Sent: 16 September 2013 21:18
To: Planning
Subject: Welwyn Hatfield Council Online Planning - Comment

Application Number: S6/2013/1787/LB *Cleaves House*
Name: John Shead *1-5 PARK STREET, #101*
Address: 136 Cole Green Lane, WGC, AL7 3JE Comment Type: Object

Proposed Plans

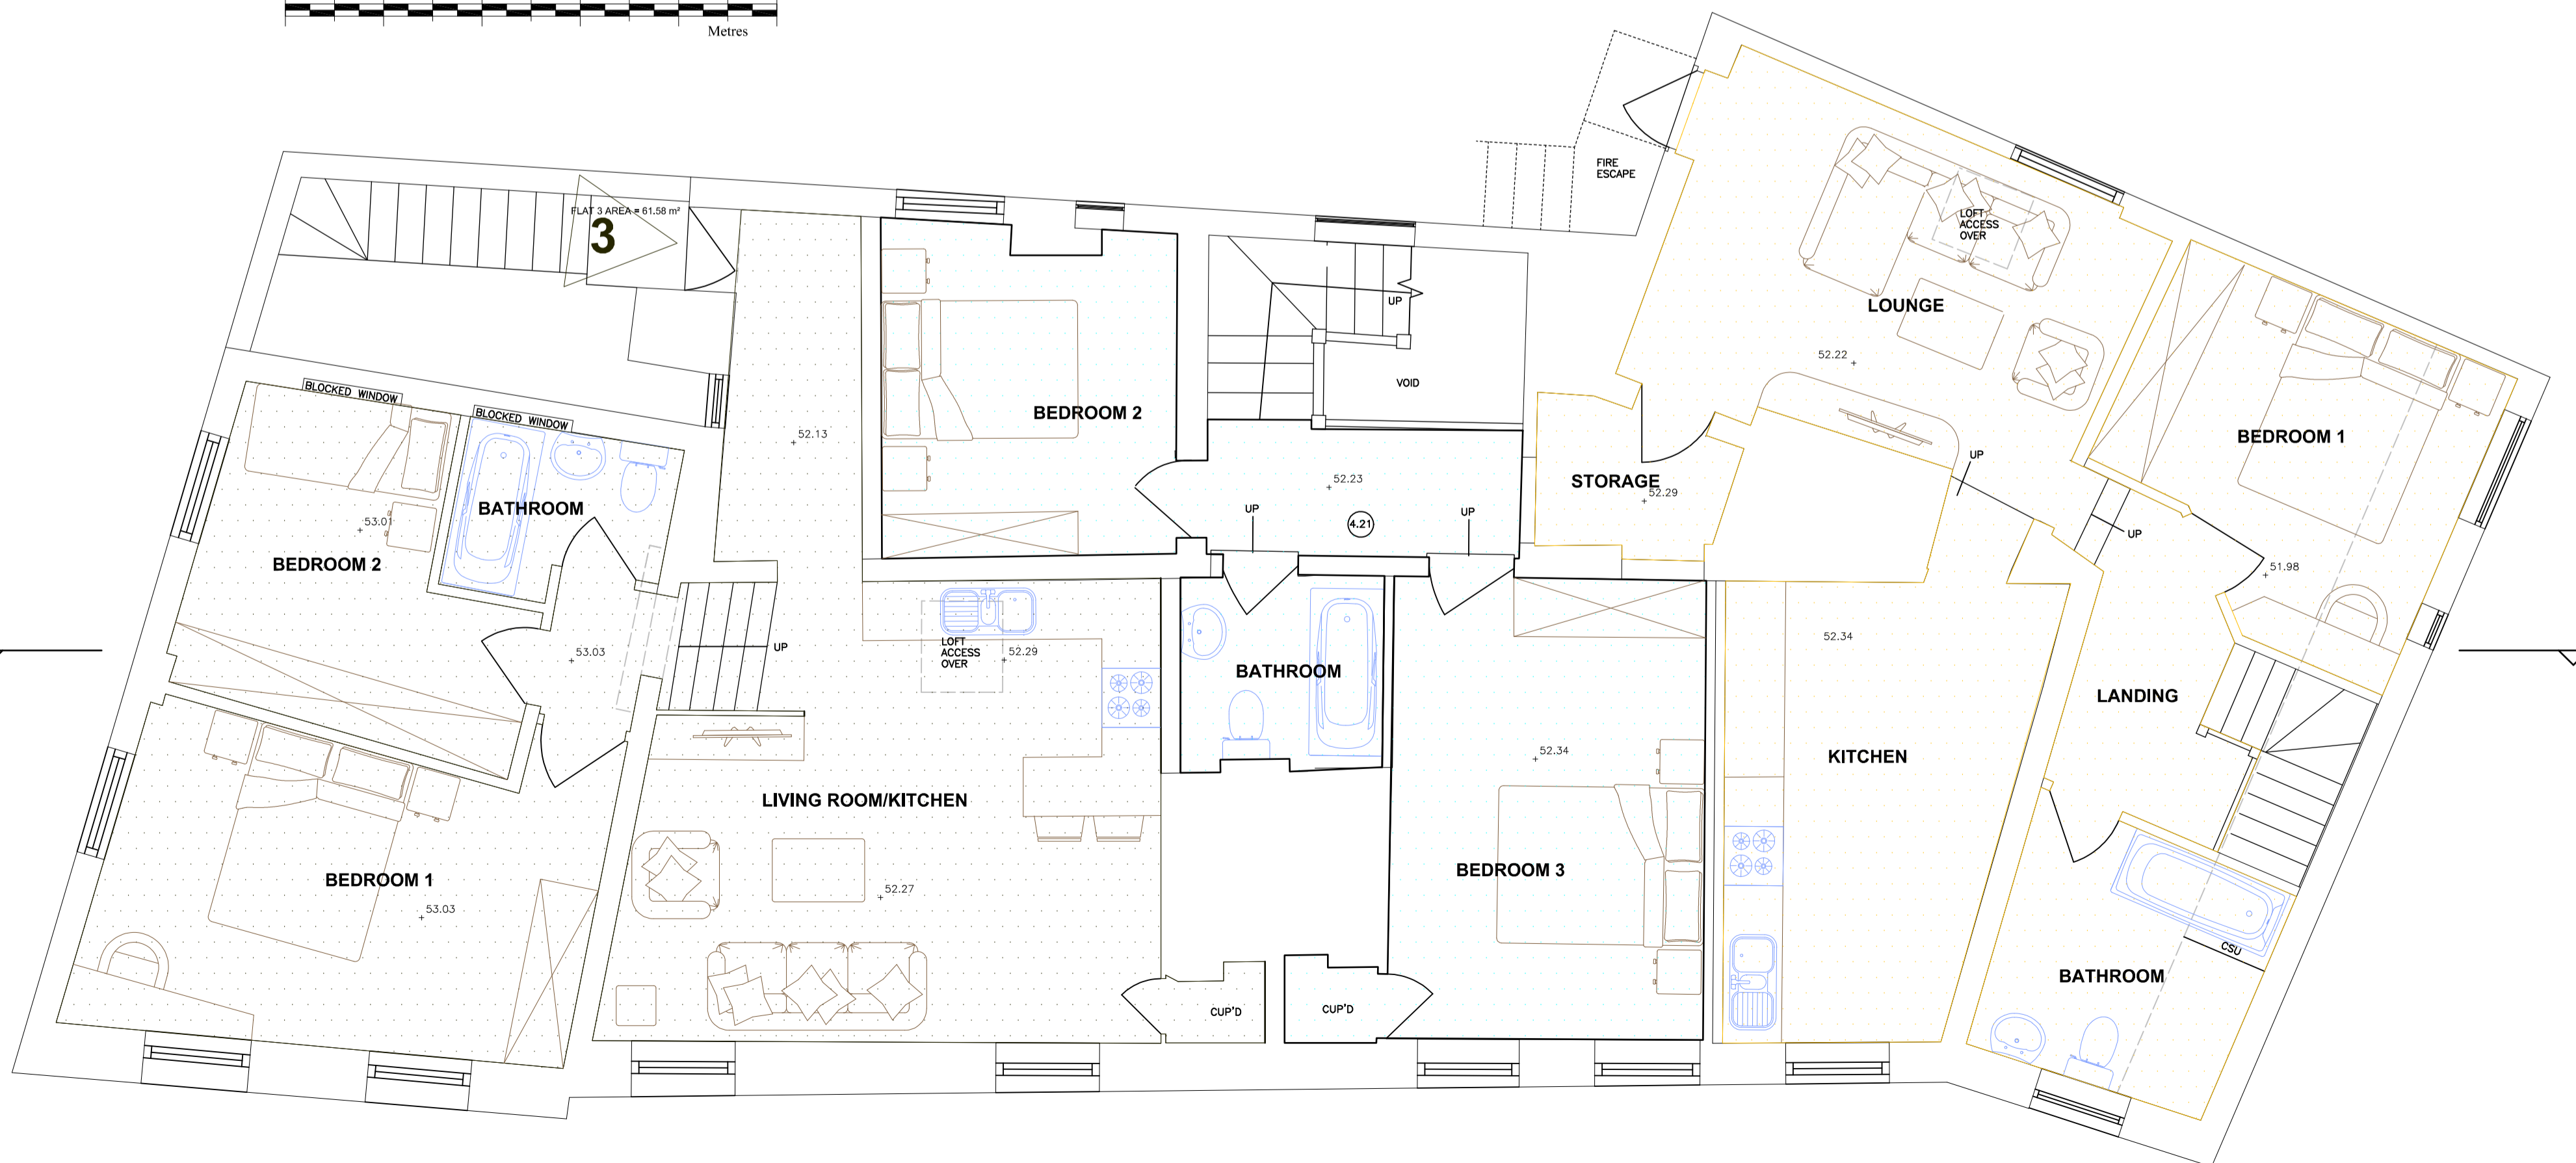
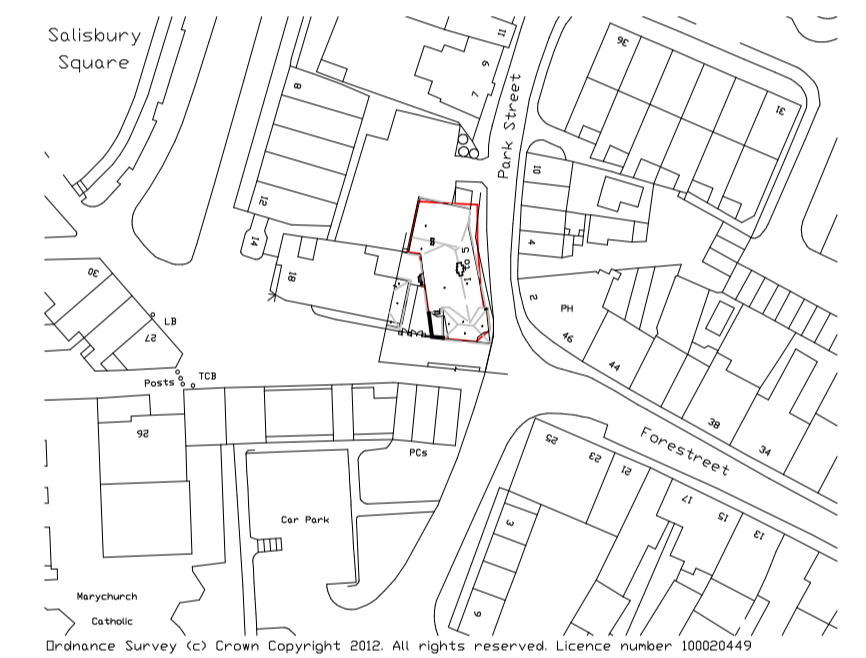
Comment: Cycle storage is inadequate. There must be at least 1 bike space per bedroom. WHDC must follow the HCC Travel Strategy and ensure that current and future generations are not prevented from cycling by the lack of built in facilities.
